**KIRKLEES METROPOLITAN COUNCIL
INVESTMENT & REGENERATION SERVICE**

**DELEGATED DECISION FOR DISCHARGE OF CONDITION -
NOTIFICATION OF A CHANGE OF USE UNDER THE ABOVE
PROVISIONS**

Reference no.	2021/CL/92282/W
Site Address	Crown House, Southgate, Huddersfield, HD1 1SW
Description	Prior approval for change of use from office (Class B1a) to 85 residential units
Recommending Officer	Stuart Howden

Officer Report

Lower Ground Floor Plan 1:100

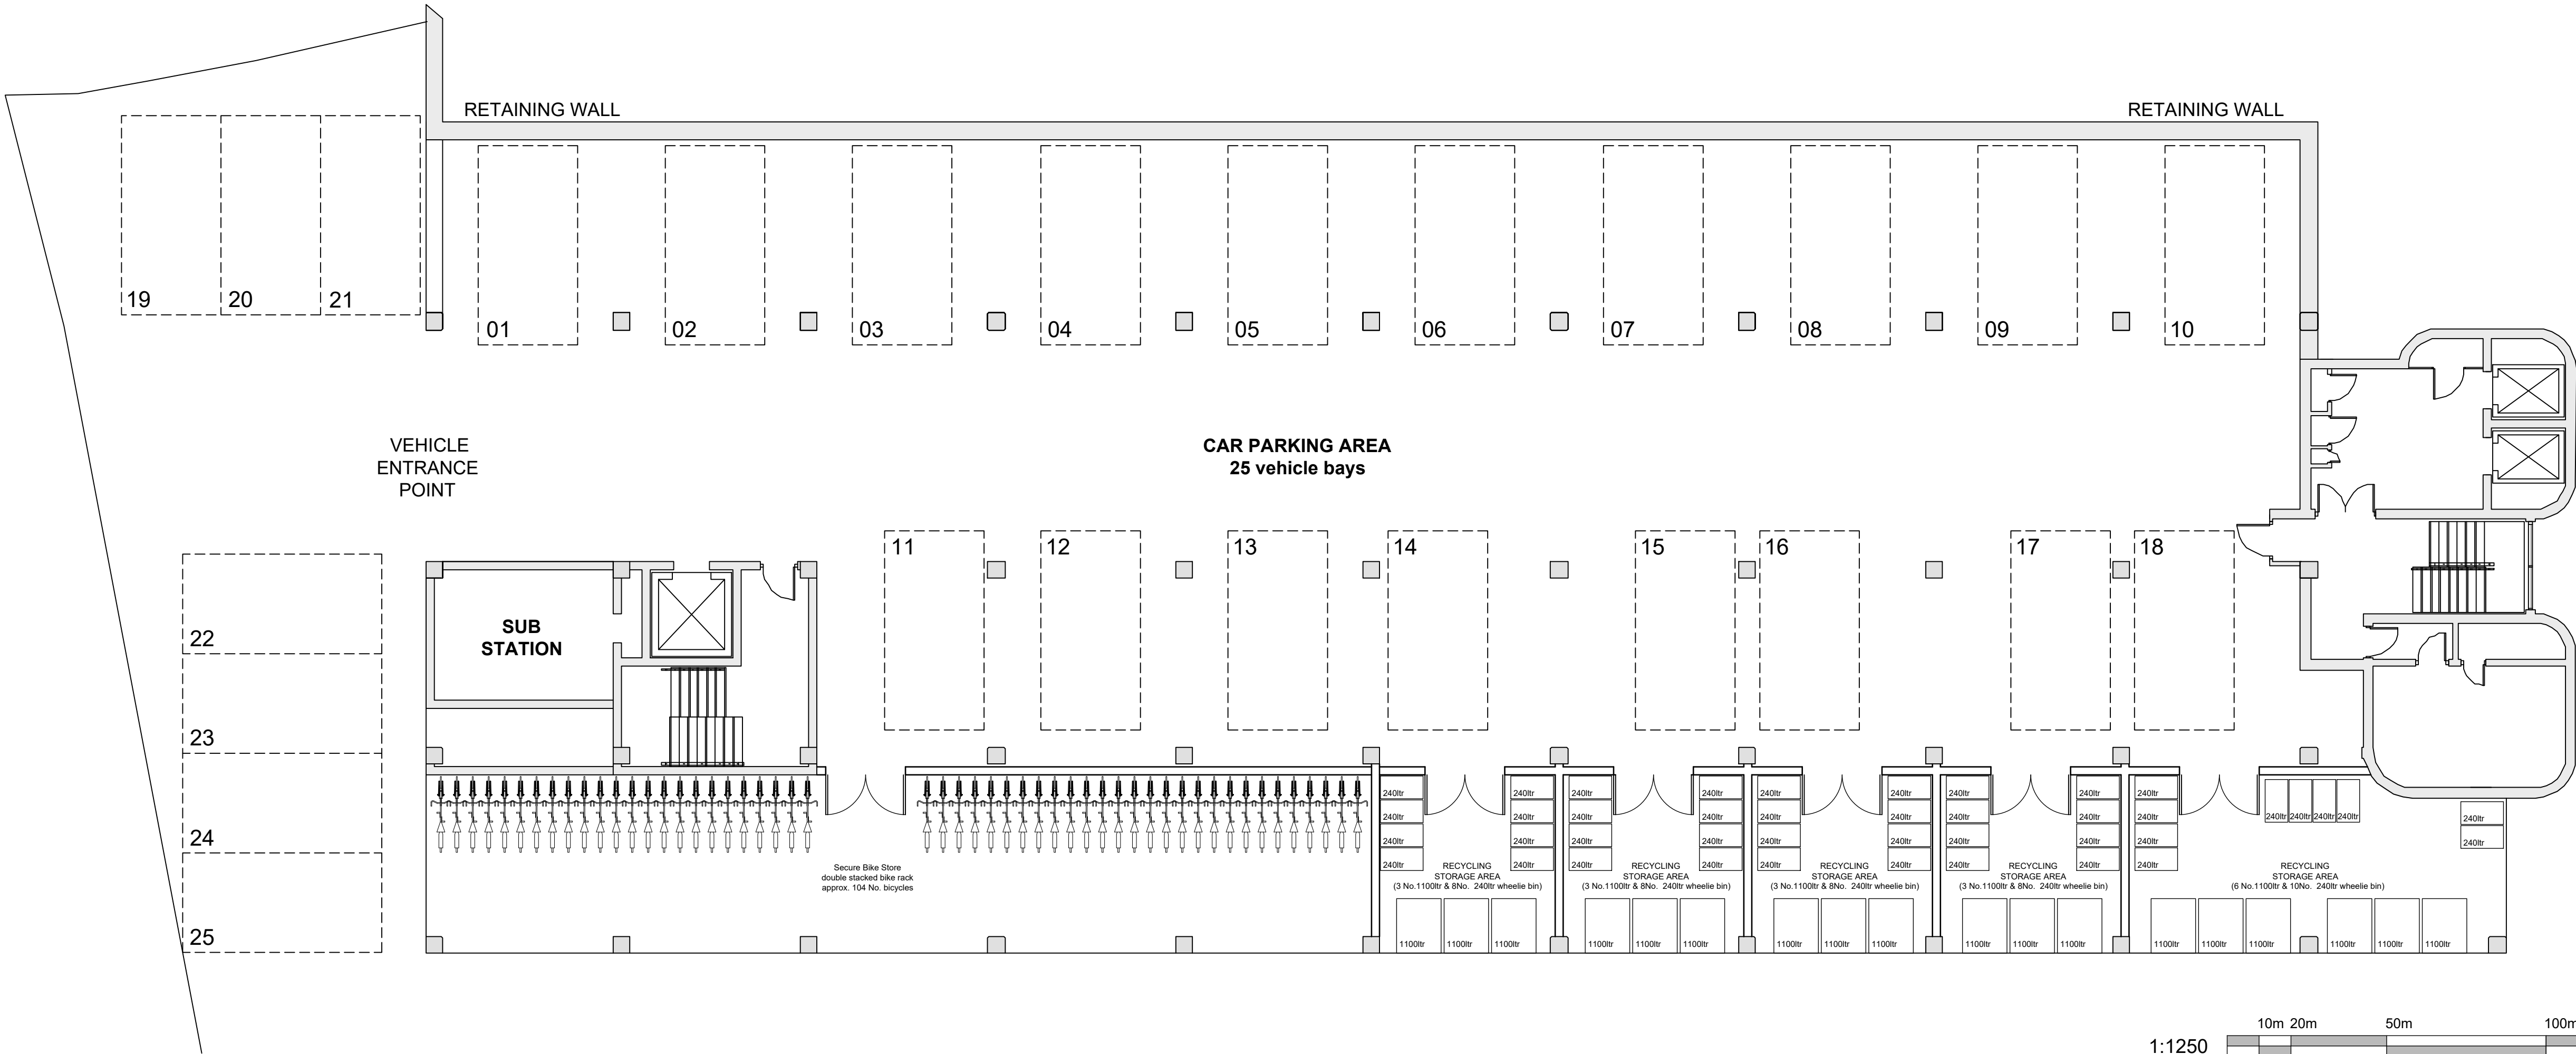
There are 25 vehicular parking spaces located on the lower ground floor of the site which are accessed from Old Leeds Road. A cover letter supporting the application notes that these spaces would serve the 85 flats proposed. It is worth noting that permission approved in September 2018 (2018/90213) related to alterations to the lower ground floor to create 7 apartments and this would result in the loss of 5 spaces. This 2018 permission is also still extant, but the proposed cycle storage displayed on the lower ground floor plan is proposed in the location of these approved apartments. If prior approval is granted and the provision of this cycle storage area is conditioned (which it is in this case as discussed further on), but the 7 apartments are constructed, this current proposal could not go ahead without breaching such a condition.

In their cover letter, the applicant's agent makes reference to the provision of secure cycle parking and the lower ground floor plan displays 104 bicycle stands, which exceeds the minimum recommended spaces outlined within the Kirklees Highway Design Guide SPD (2019) (which advises one space per dwelling). The provision of such cycle storage would support further sustainable transport options for future occupiers. The provision of this could be secured through condition.

With regard to waste, the existing access point is considered to be large enough to accommodate an 11.85 metre refuse collection vehicle and other small delivery vans to the site. A refuse storage area is displayed at the lower ground floor area containing 18 no. 1100ltr bins and 42 no. 240ltr wheelie bins (which are accessible to the apartments) and this is considered to be broadly consistent with guidance contained within the Kirklees Waste Management Design Guide (2020) with reference to the number of apartments proposed. A suitable route for the bins to be manoeuvred to the refuse collection vehicle will also need indicating taking into account the size of wheelie bins required. In light of this matter a condition will be attached should permission be granted requiring the submission of waste collection details.

1. Prior to the first occupation of the apartments hereby approved, 104 cycle stands shall be installed on the lower ground floor in accordance with Drawing No. jw1024-100 and made available for use by residents. The cycle stands shall be retained as such thereafter.

2. Prior to first occupation of the apartments hereby approved, at least 2 no. vehicle recharging points shall be installed in the car park of the hereby approved development. Cable and circuitry ratings shall be of adequate size to ensure a minimum continuous current demand of 16 Amps and a maximum demand of 32Amps. The electric vehicle charging points so installed shall thereafter be retained.

3. Prior to the first occupation of the apartments hereby approved, the bin storage area shall be provided on the lower ground floor in accordance with Drawing No.jw-1024-100 and made available for use by residents. The bin storage area shall be retained as such thereafter.

4. Prior to the first occupation of the apartments hereby approved, full design details of the route for the bins to be manoeuvred to the refuse collection vehicle shall be submitted to and approved in writing by the Local Planning Authority. Thereafter, the development shall be in accordance with these approved details.

description:
Proposed Floor Plans
Ground & First Floors

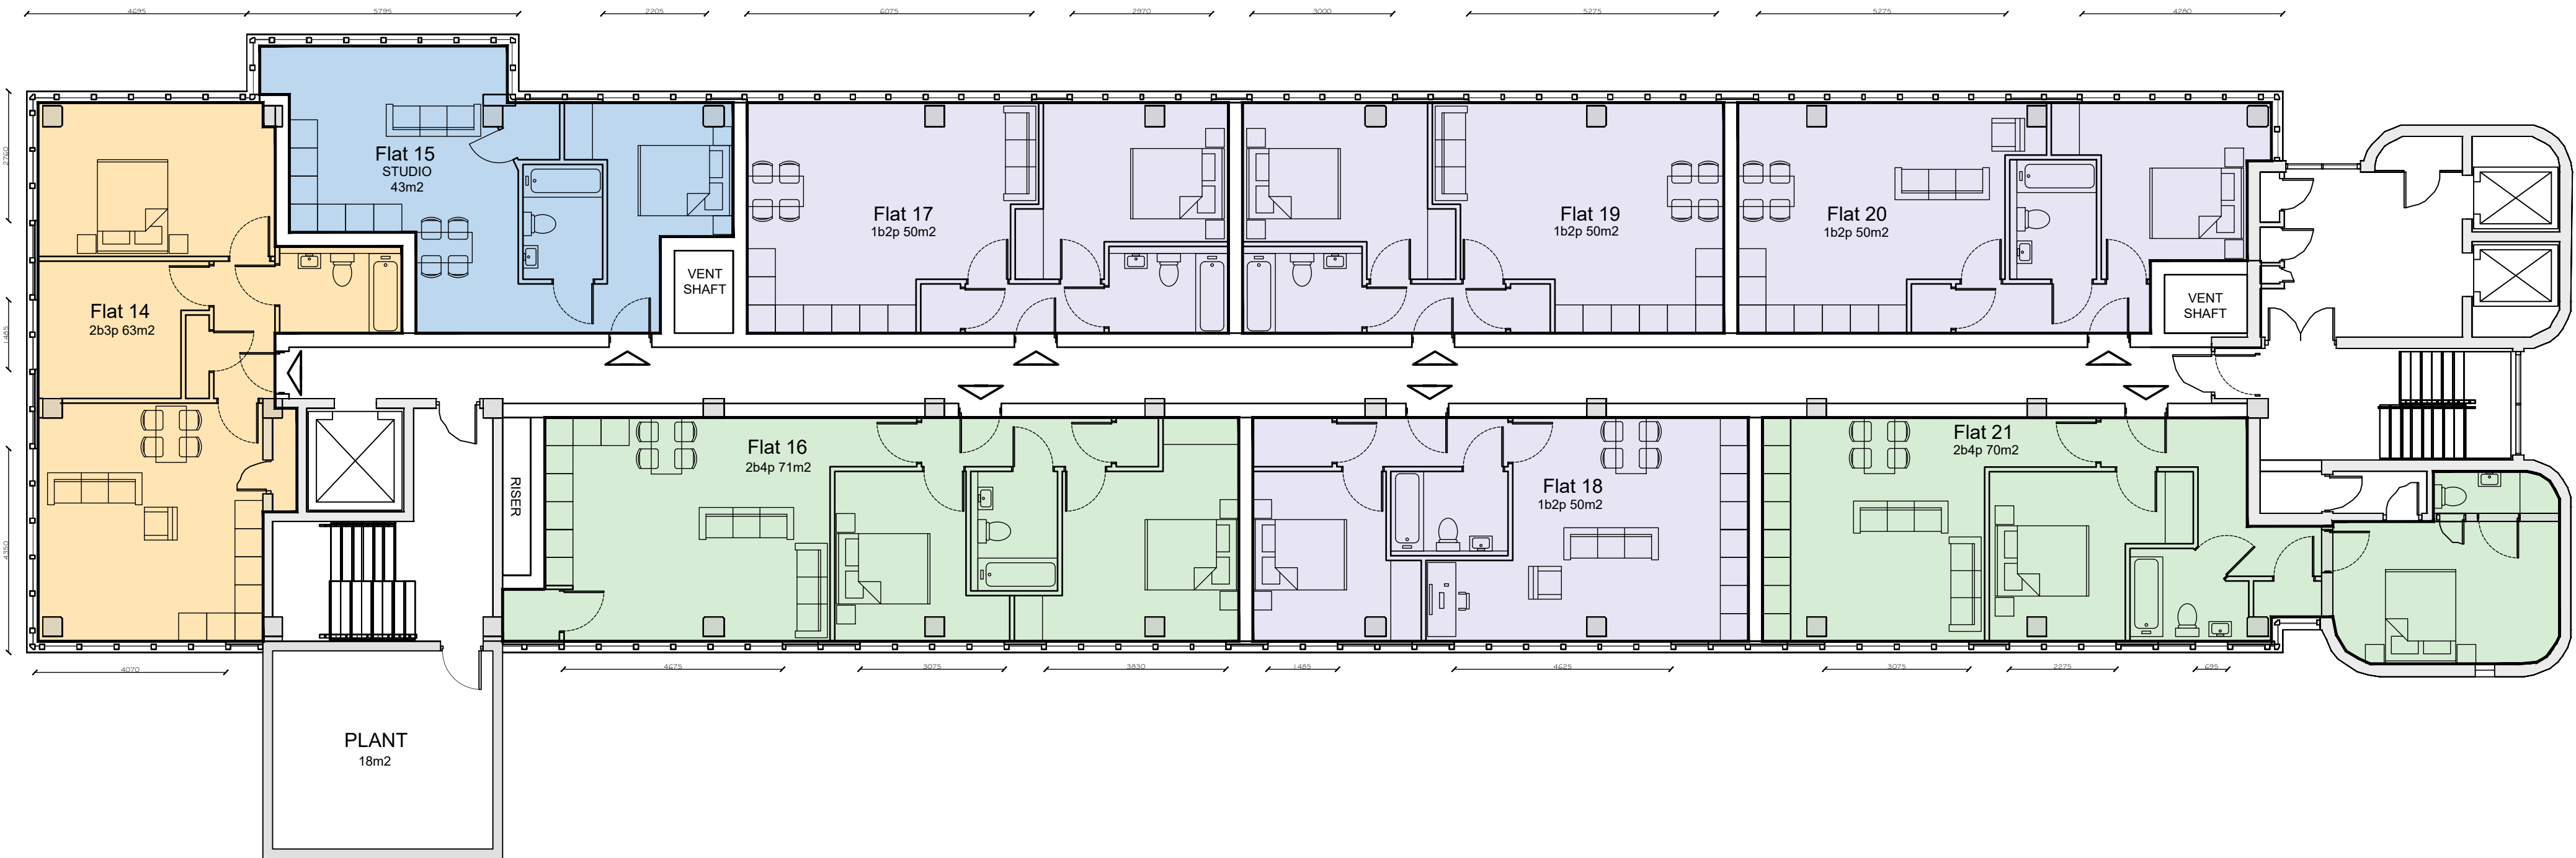
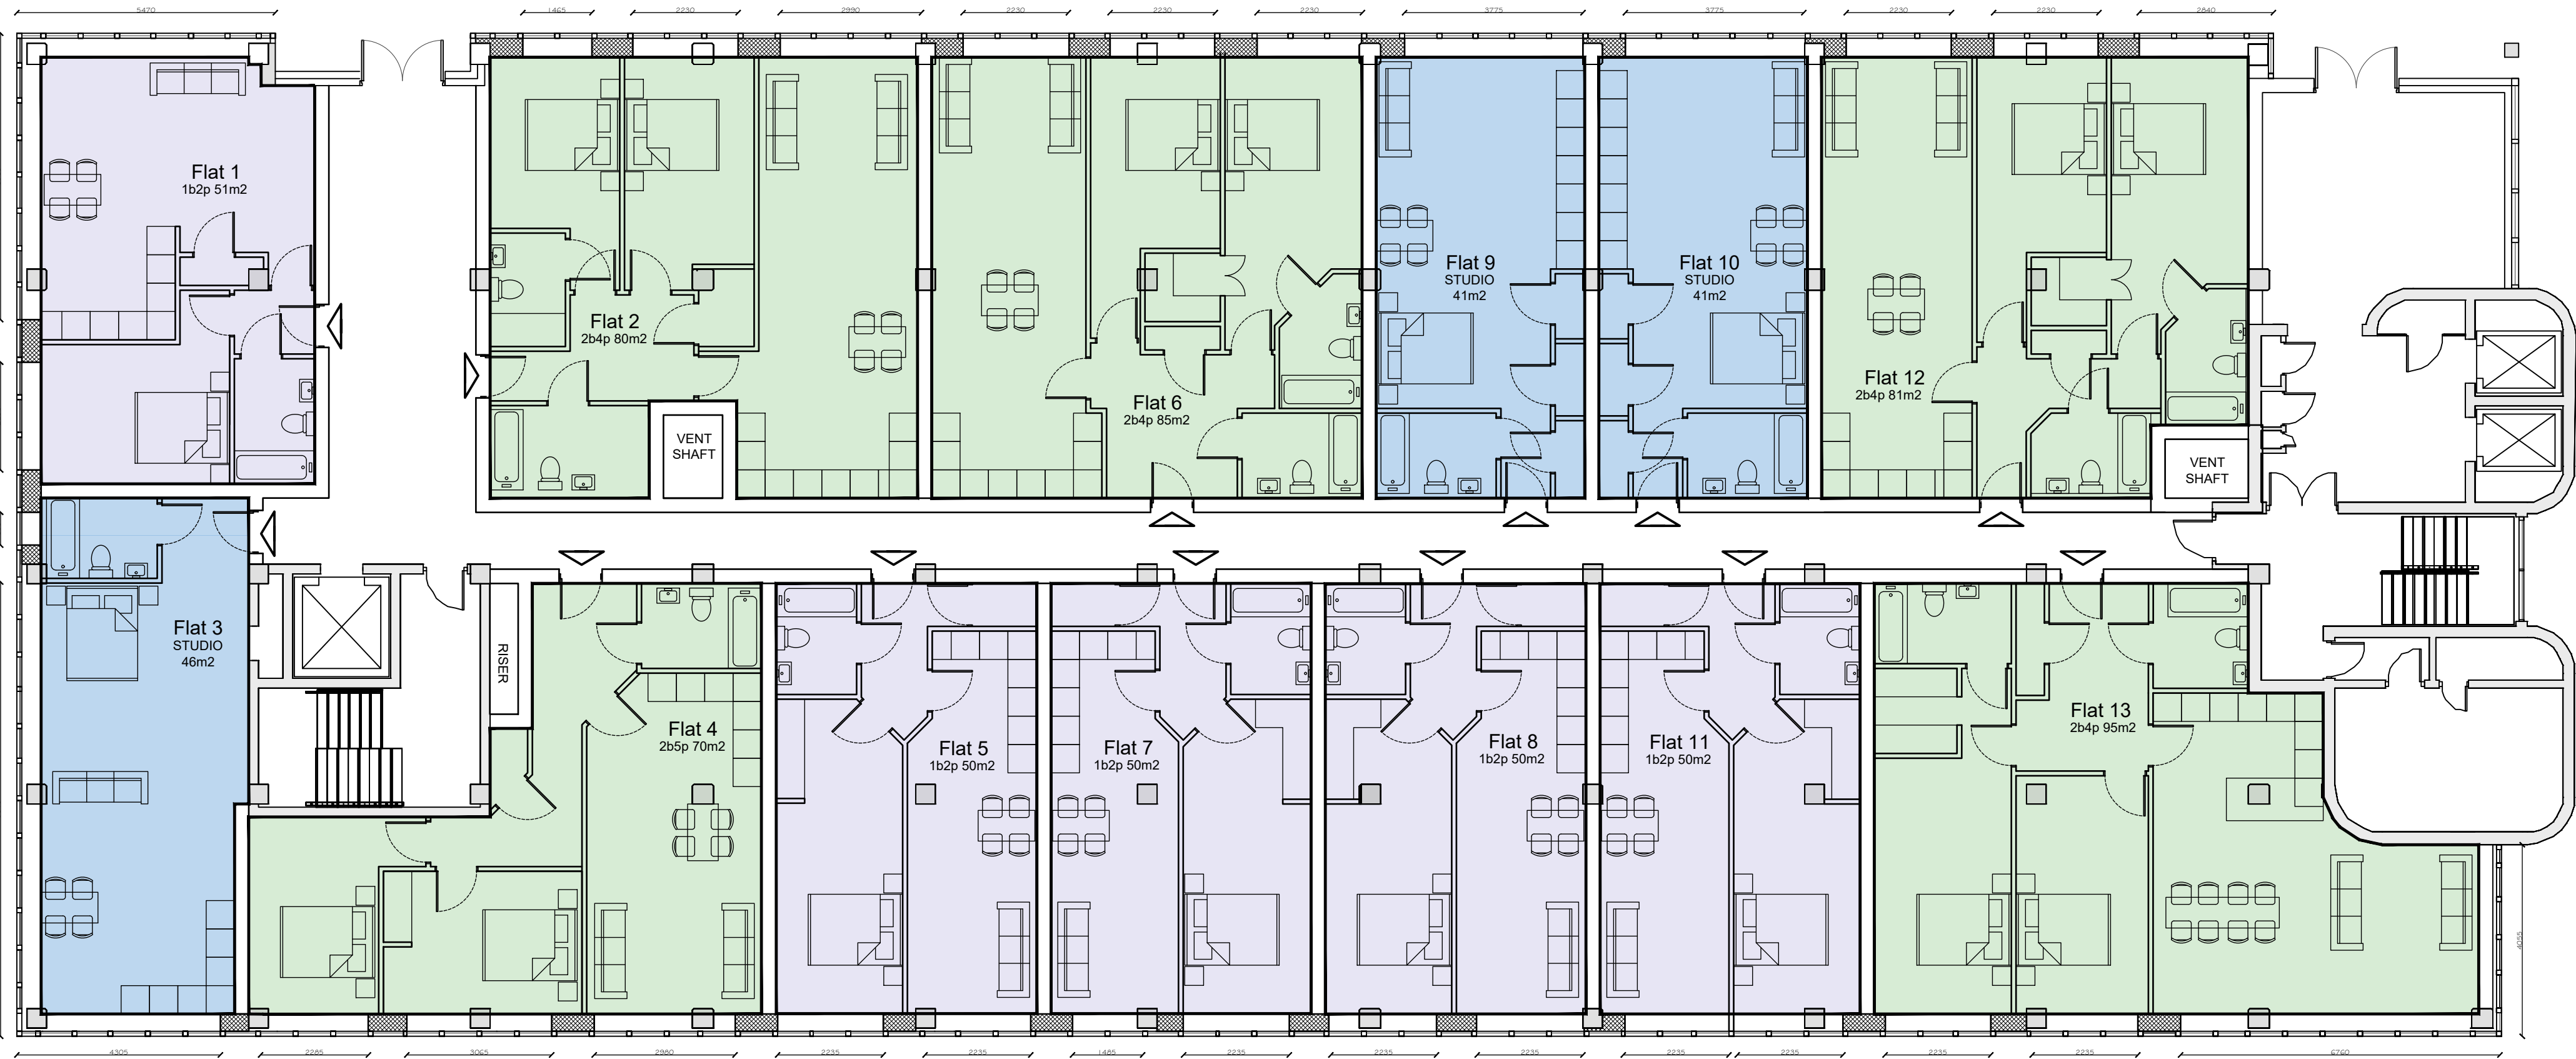
Floor plans and elevational drawings have been submitted outlining the size of the apartments and the specific rooms found within them. Officers consider that all apartments are provided with sufficient light as all habitable rooms have access to at least one windows of adequate size.

A mixture of studio, 1 bed and 2 bed apartments are proposed. Having assessed the floor plans and the apartment schedule submitted alongside the application, Officers are satisfied that all the proposed units meet the required standards outlined within the NDSS and are therefore deemed to be acceptable under Part 3 of the GPDO.
